RESOURCE RECOVERY FACILITY, EASTERN CREEK (SSD-9774) RESPONSE TO REQUEST FOR FURTHER INFORMATION

I refer to your correspondence of 25 January 2022, where you requested further information in relation to SSD-9774, being a State Significant Development Application for a new Resource Recovery Facility, at Hanson Place, Eastern Creek.

DRAWING TITLE				
DRAINAGE PLAN SHEET 2				
PROJECT NO.	PLANSET NO.	RELEASE NO.	DRAWING NO.	REVISION
P1806739	PS02	R07	PS02-E101	B

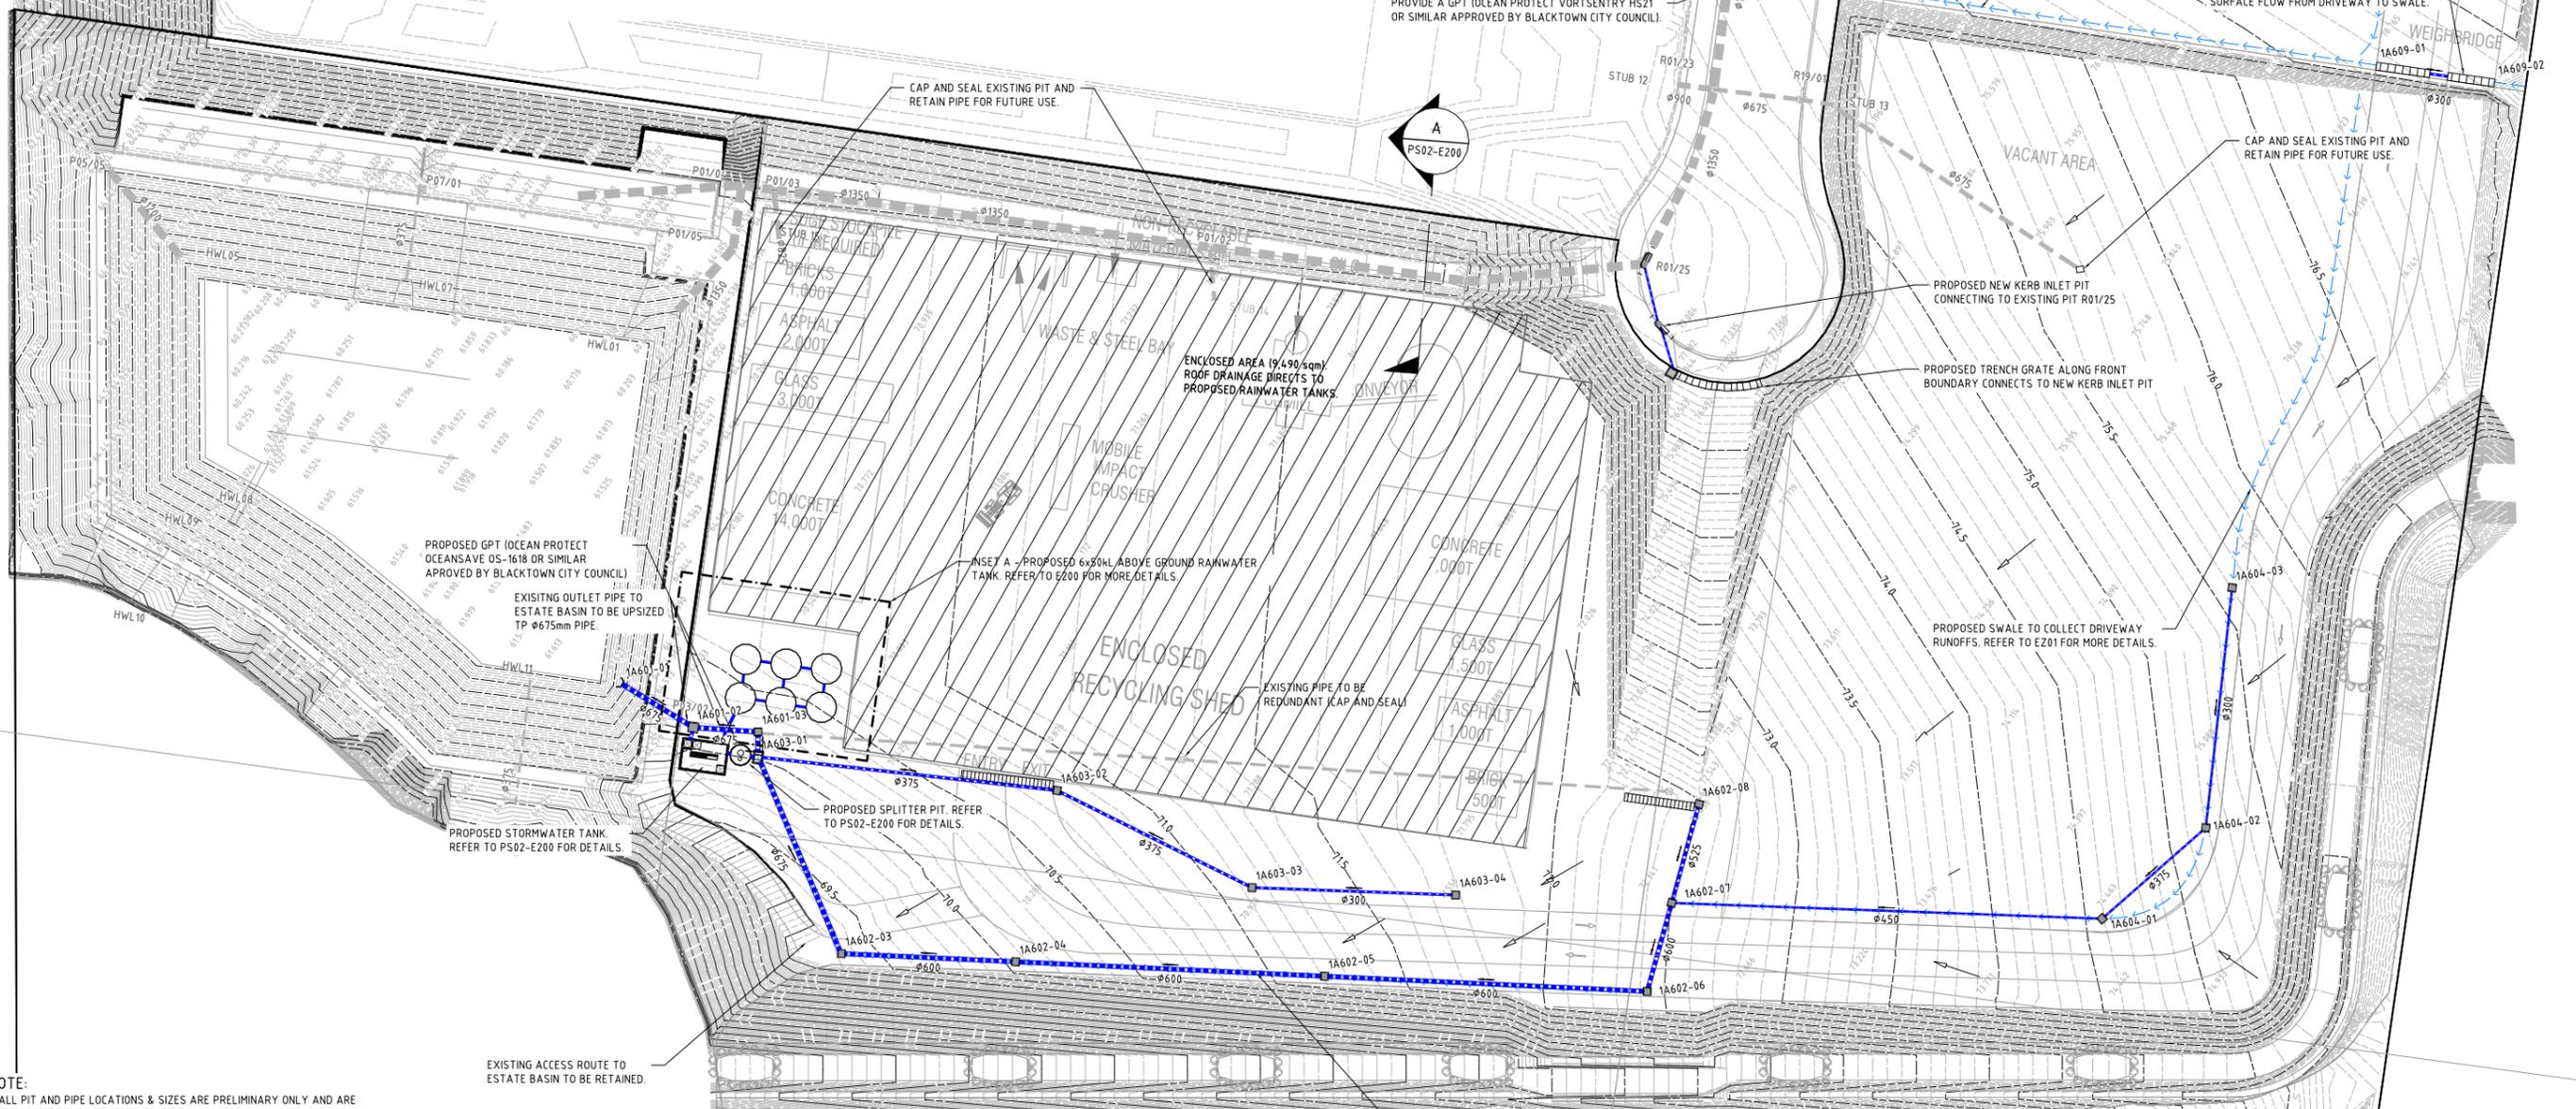
2. **Flooding:** Council identifies concerns in relation to flow of 1% Annual Exceedance Probability flooding flows at the trapped low point at the end of Hanson Place cul-de-sac. Council requests further details of how the flow overtops the kerb or boundary and how these flows are safely collected and then directed to the swale and on to the estate wetland and detention basin. Council note that the flow width at the boundary is likely to be much larger than the 10 m wide channel. Council also notes that there is a discrepancy in the contours around the trapped in the cul-de-sac. Council therefore requests:

- Additional survey to correctly understand the actual overtopping of the cul-de-sac and ensure the swale width is increased sufficiently to collect and direct the flow to the main design swale with freeboard and that the main building is protected.

- Detailed hydraulic flood modelling that demonstrates the behaviour and extent of flows overtopping the cul-de-sac in a 1% AEP event. Where the modelling demonstrates that the width of flow exceeds the 10 m wide swale detail what measures are required to safely collect such flows and direct these back into the swale without adversely impacting the proposed building within the site or in particular the adjoining development at 22 Hanson Place. Show both pre and post development modelling to show no impacts on 22 Hanson Place. Where such modelling demonstrates some of this flow enters the main driveway to lots 4 and 5, detail how such flows are collected and conveyed to the estate basin to ensure no adverse impacts to the main building and operations of the site. In addition, are there safety issues for access/egress from the site down a steep driveway in such 1% AEP events and how is this addressed.

Martens has undertaken a review of the flooding issues raised by Council, and a detailed response is provided in **Attachment A**. In summary it is highlighted that the existing cul-de-sac of Hanson Place, and the swale running along the northern boundary of Lot 5, were constructed as part of the sub-division works of the estate. This is a modern and recently completed subdivision development and the design of all infrastructure, including the stormwater drainage system, should be understood to have been undertaken to appropriate standards. It is therefore appropriate for Hanson to rely on the adequacy of the Council infrastructure in Hanson place to safely direct stormwater flows in accordance with the design concept. No modification works have been proposed on the cul-de-sac and the swale as part of the current proposal.

However, given Council's stated concerns it is proposed that detailed hydraulic modelling of the cul-de-sac and swale entry could be completed at the construction certificate (CC) stage, which would assess the extent and behaviour of any potential overtopping flow from the cul-de-sac and determine if further stormwater measures would be required to prevent this overtopping in to the Site or, if this cannot be achieved, to accommodate these flows. Should works be required within the site to manage additional upslope flows, these can be readily integrated into the on-site drainage design.

PRELIMINARY PIPE SIZING								
PIPELINE FROM SPLITTER PIT TO ESTATE BASIN	5% AEP FLOW RATE ESTIMATION				PIPE CAPACITY			
	C100	I (mm/hr)	A (ha)	Q(L/s)	D (mm)	S(%)	Qcap(L/s)	
PIT 1A602-02 TO 1A601-02	1.05	168	1.93	94.6	675	1	993	
PIT 1A601-02 TO 1A601-01	1.05	168	2.97	1455	675	7.71	2760

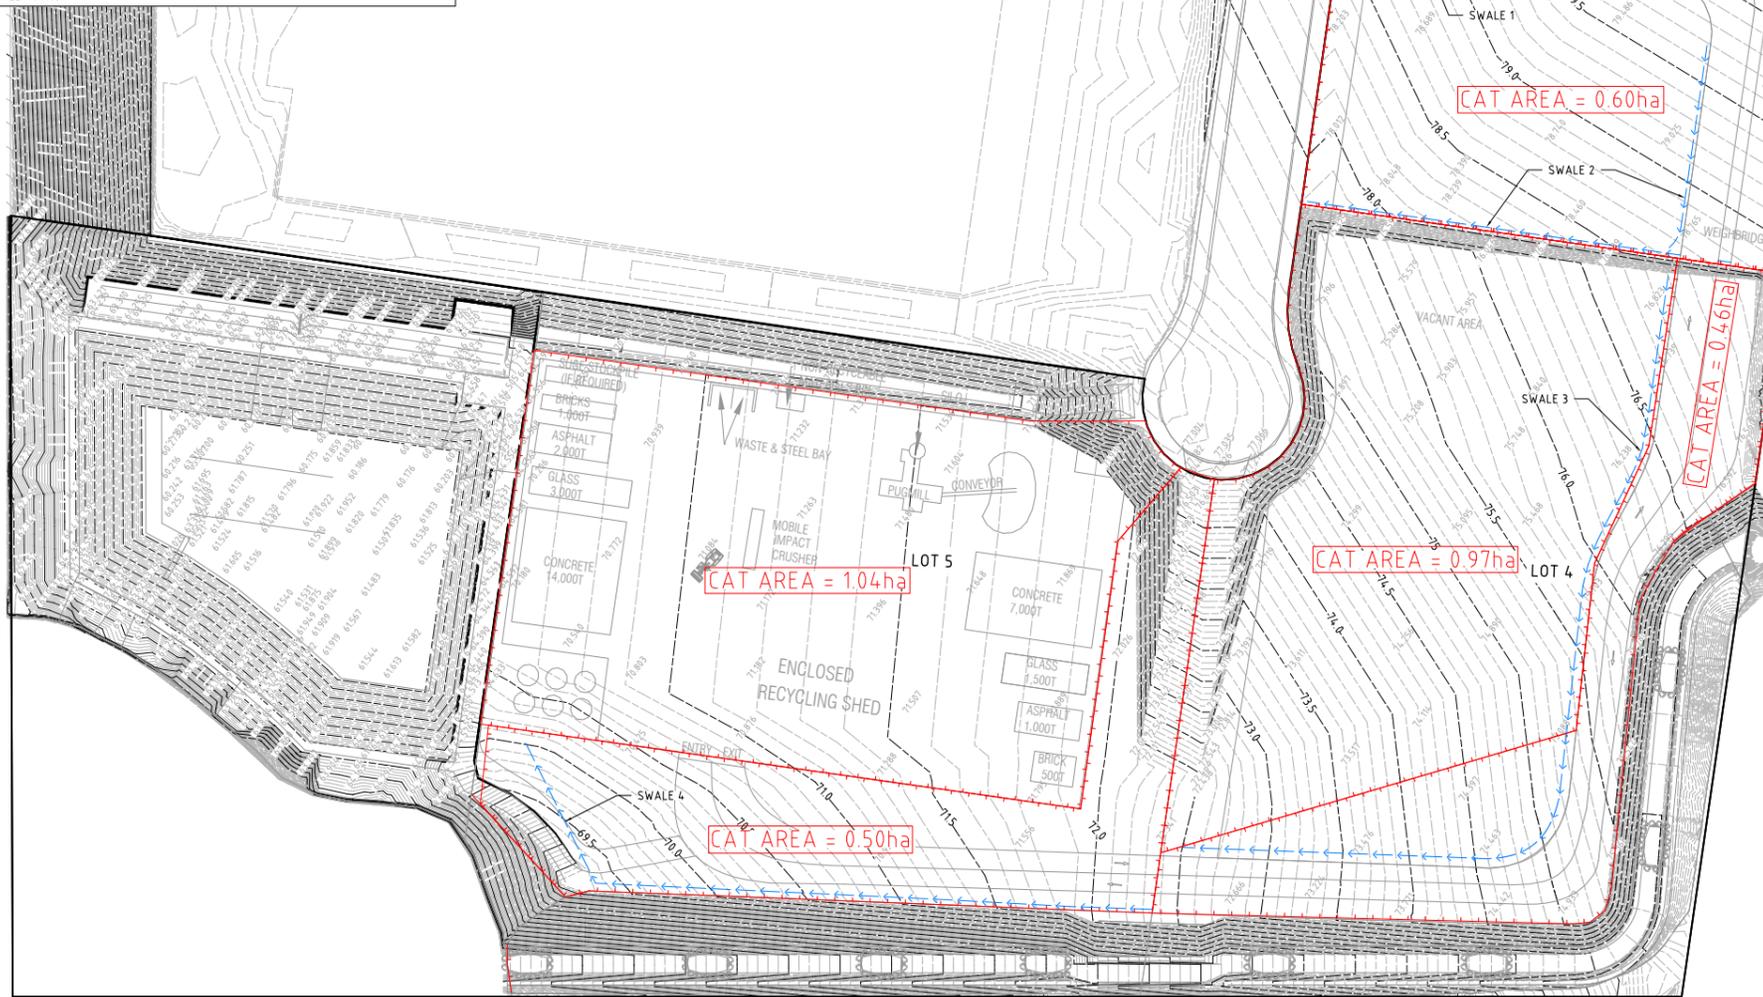
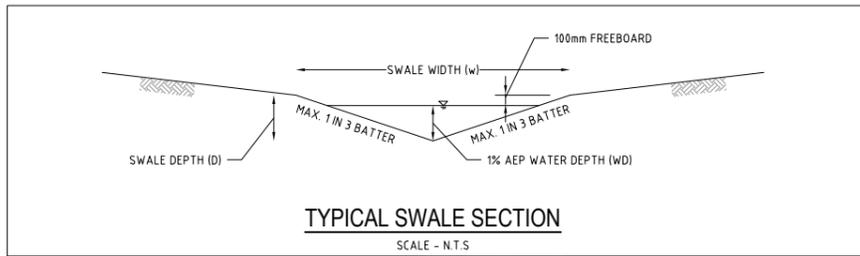
- Hard standing of the vacant and unused area located in the middle of the site marked as ‘Equipment Storage Area’. Council considers that a compacted natural earth finish is not acceptable, and recommends that this area should have an all-weather sealed finish such as new concrete or bitumen, capable of carrying the heavy axle loads of the trucks proposed on site.
- Pit and Pipe Network and Hydraulic Modelling: Council note that the site is large and the number of pits supplied to collect the flows are insufficient. The number of inlet pits needs to be increased. The pit and pipe system need to be designed for the 5% Annual Exceedance Probability flows with the catchment 100% impervious. Council requests a DRAINS model or other hydraulic calculations to justify that the internal pit and pipe system can collect and convey the 5% AEP flows to the estate basin.

Hydraulic Modelling of the Pit and Pipe Network: The proposed drainage design is conceptual only for the purpose of development assessment. Final design with full detailed hydraulic analysis is intended to be completed as part of the Construction Certificate. As documented in the updated Water Cycle Management Plan (see **Attachment B**) the outlet pipes have been sized to convey the 5% storm flows in accordance with Council’s requirements, and this will be confirmed via further hydraulic modelling at the Construction Certificate stage. If the number of pits needs to increase, then that can easily be included in the detailed design at that time. Any requirements for the detailed design can be addressed by way of a condition of consent.
